# 2021 Financial Assurance Estimate Form (with pre-plat construction)

PROJECT INFORMATION			
Winsome Filing No. 2	5/25/2021		
Project Name	Date	PCD File No.	SF-21-015

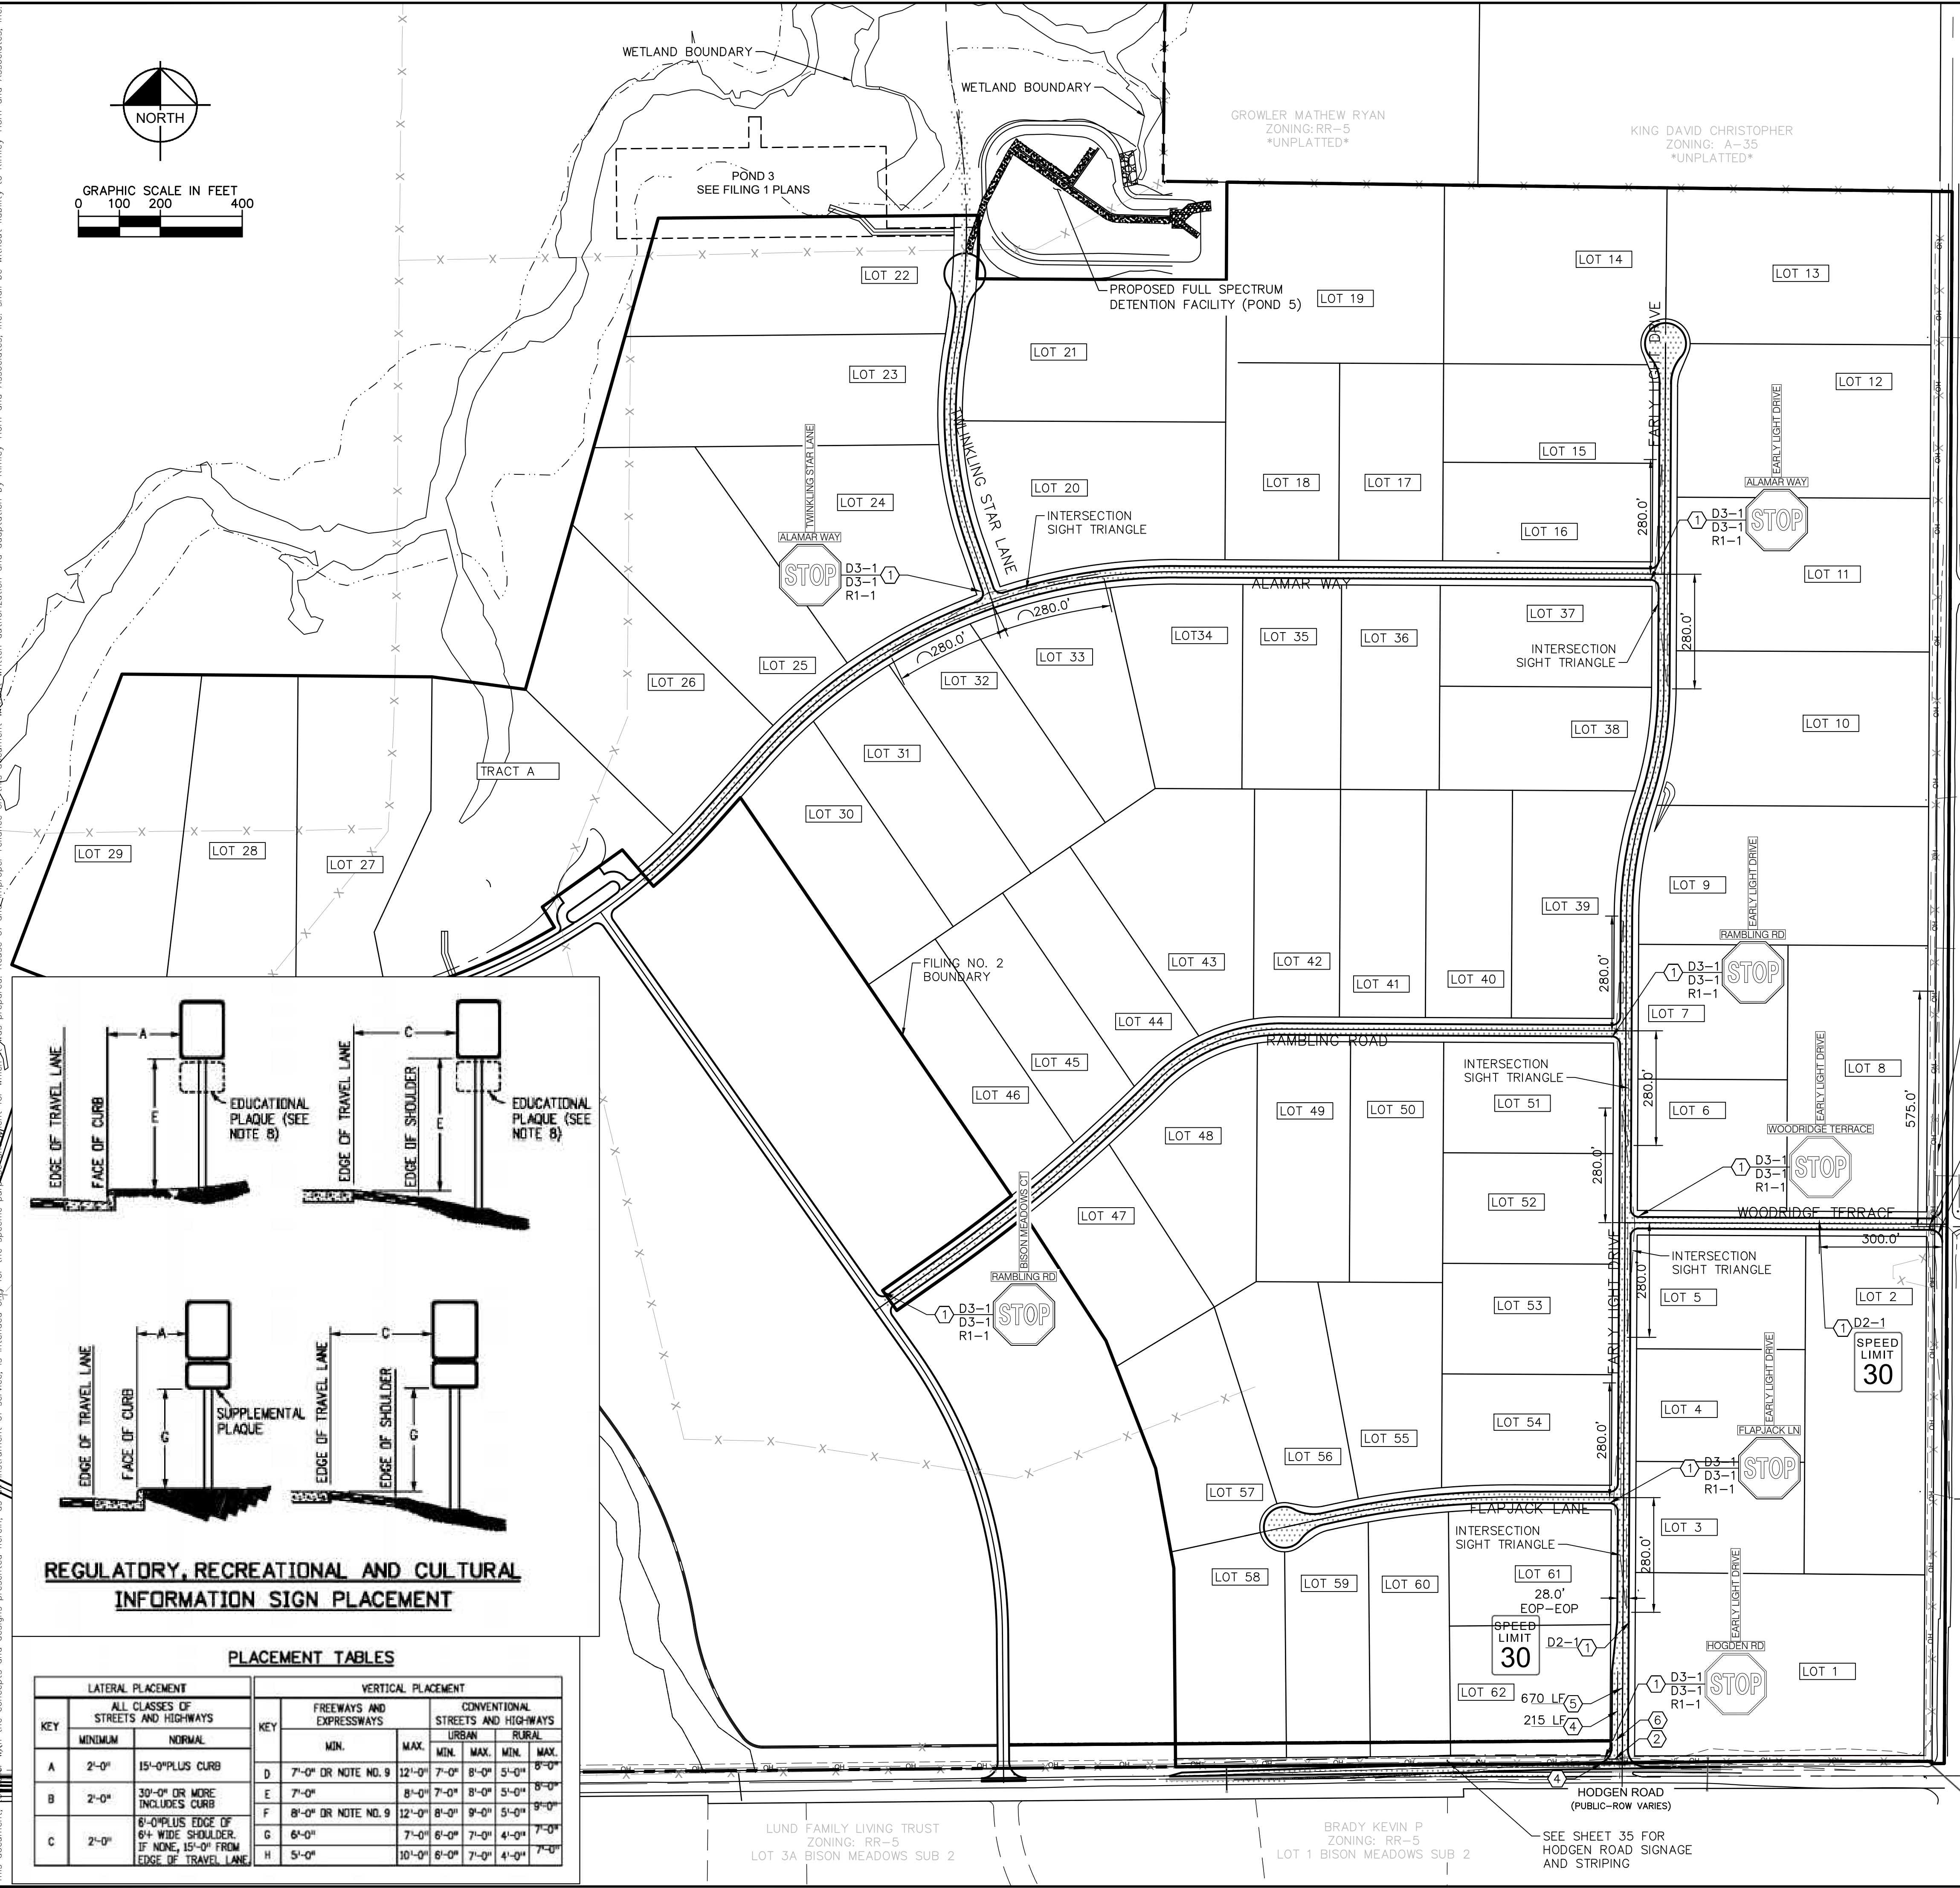
Add 1 Type 3 barricade  
per CD sht 24
